Date: May 14, 2021

**To: Director Social and Infrastructure Assessments
Planning and Assessment
NSW Department of Planning, Industry and Environment
Locked Bag 5022
Parramatta NSW 2124**

**Re: Significant Development Modification: Fort Street Public School
Application No. SSD-10340-Mod-1**

DA-7111 — Building 3 - Private VIA View 11  
Department of Education — Fort Street Public School

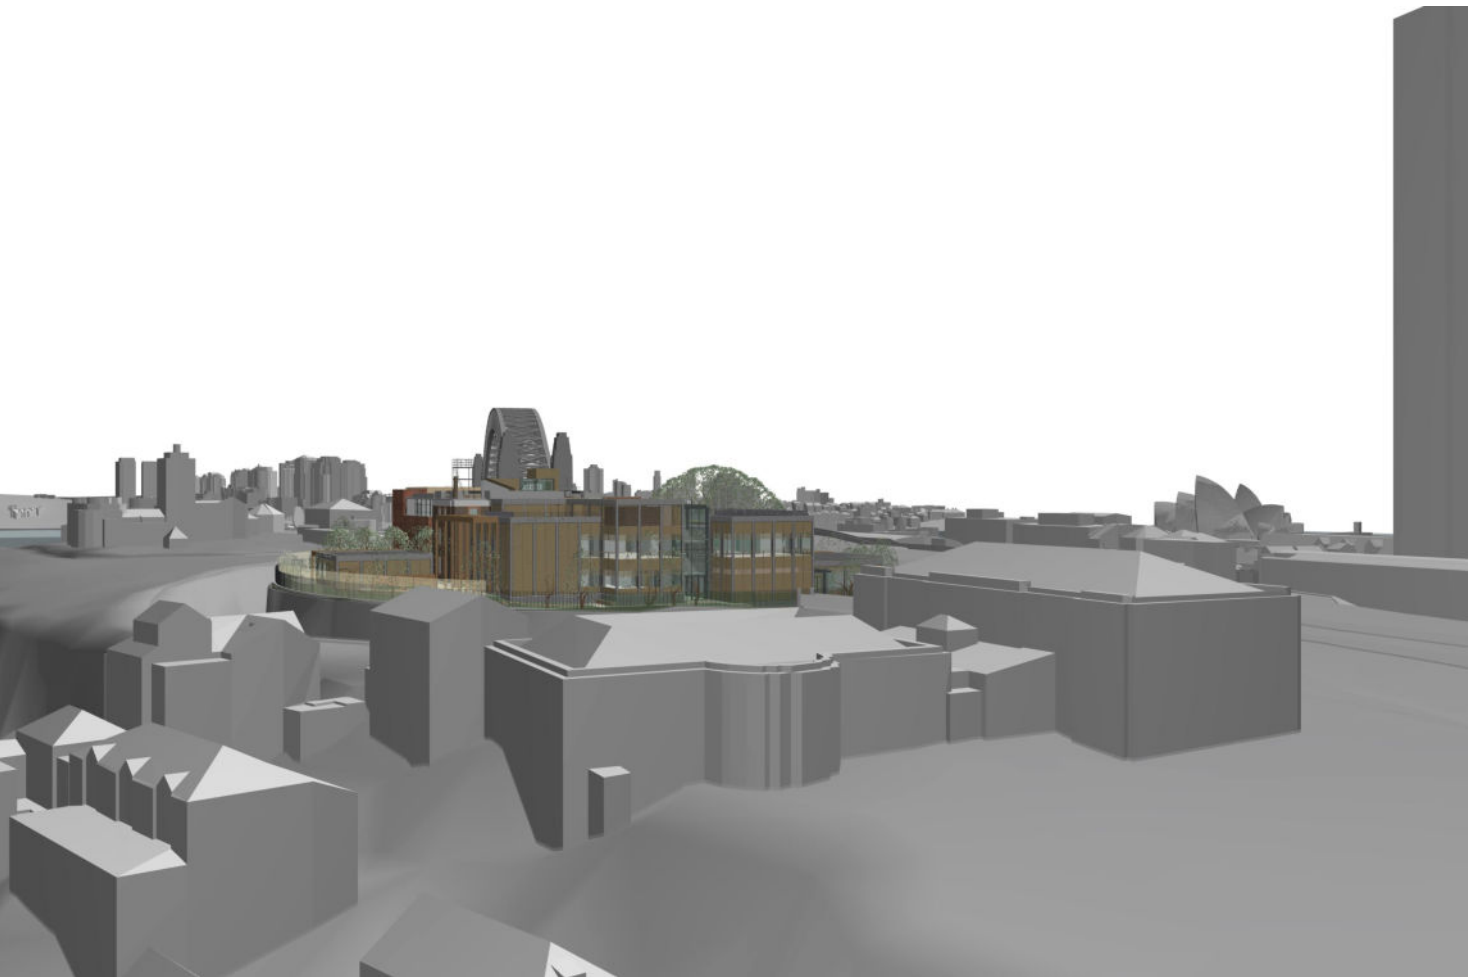
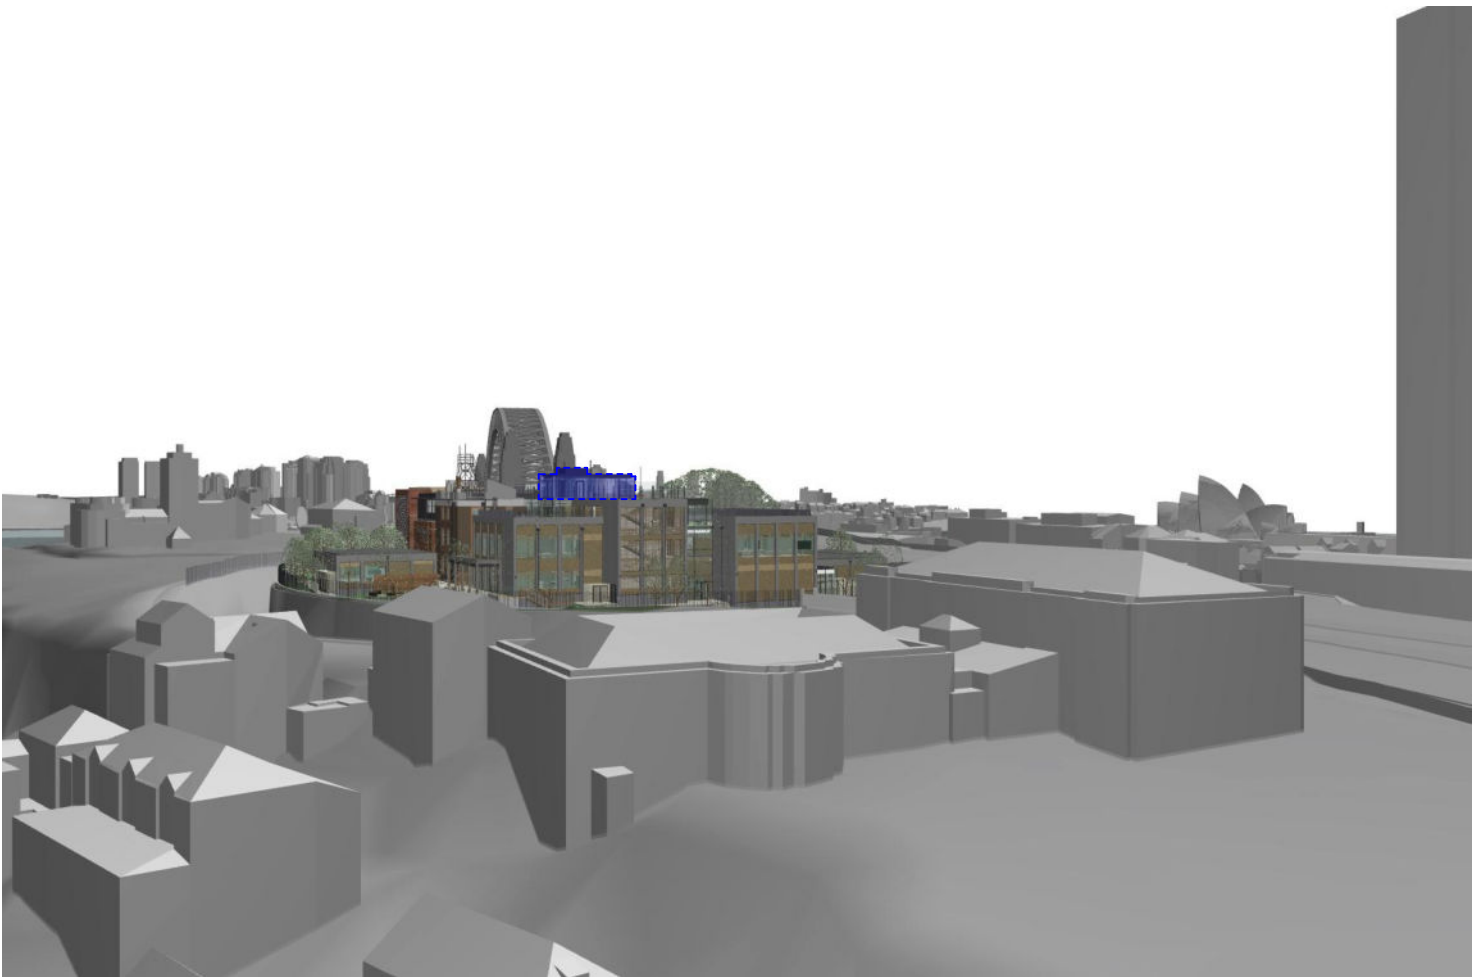
However, it appears that the proposed modifications include an increase in height, bulk and scale when compared the original proposal. The imagery provided (viewpoints 1 to 11) does not clearly indicate the impact of the proposed modifications in relation to residents of nearby apartments.

Without further clarification, I must strongly object to the proposal, which increases the height and bulk of Building J in particular, beyond the original approval.
